OFFICIAL NOTICE OF DECISION

**Project#: PR-2024-010951 aka
PR-2024-010617
Application#
SP-2025-00061 SITE PLAN ADMINISTRATIVE DFT**

**Lot/Tract 165, TOWN OF ATRISCO GRANT
AIRPORT UNIT zoned MX-M, MX-L,
located at 724 64TH ST NW. (J-10)**

1. This is a request for Phase 1 of the West Mesa Ridge development, consisting of 128 multi-family residential units, and located at Coors Blvd. NW and Glenrio Rd. NW, north of Fortuna Road NW.

Outside the territory

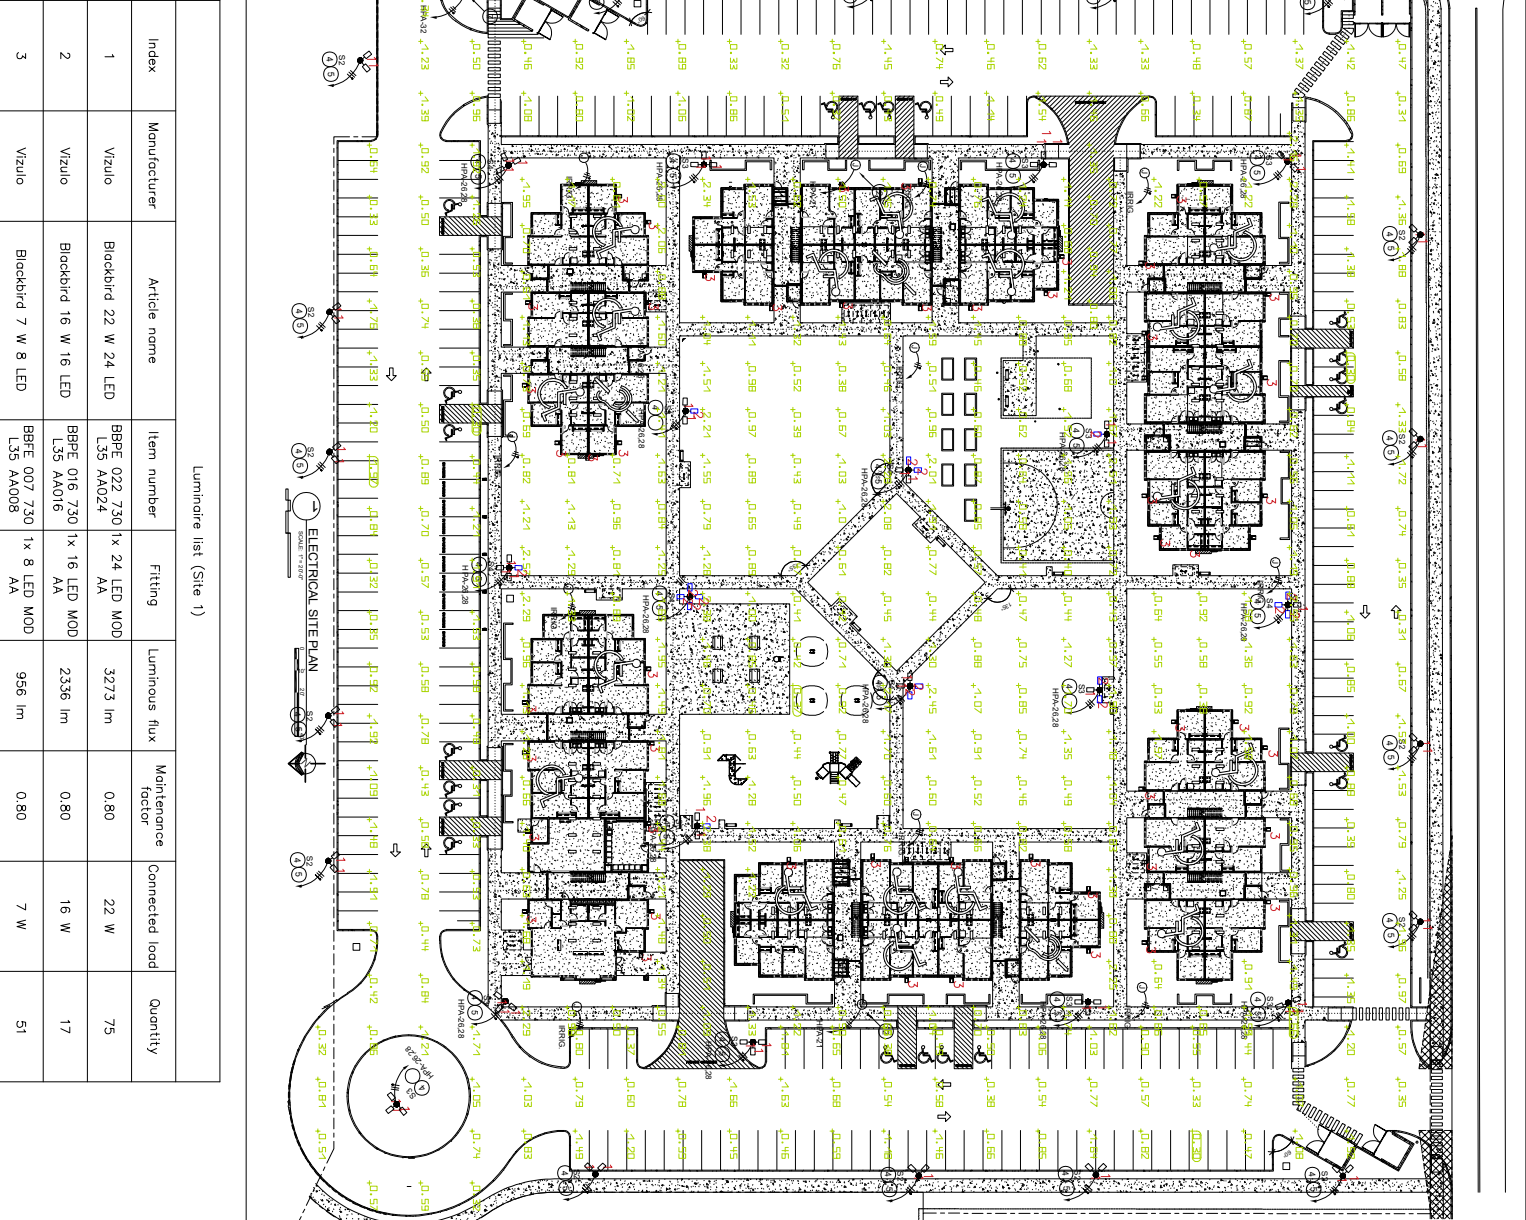
1. Clarify at what point the light is being measured as represented in the “Outside the Territory” Photometric Plan.
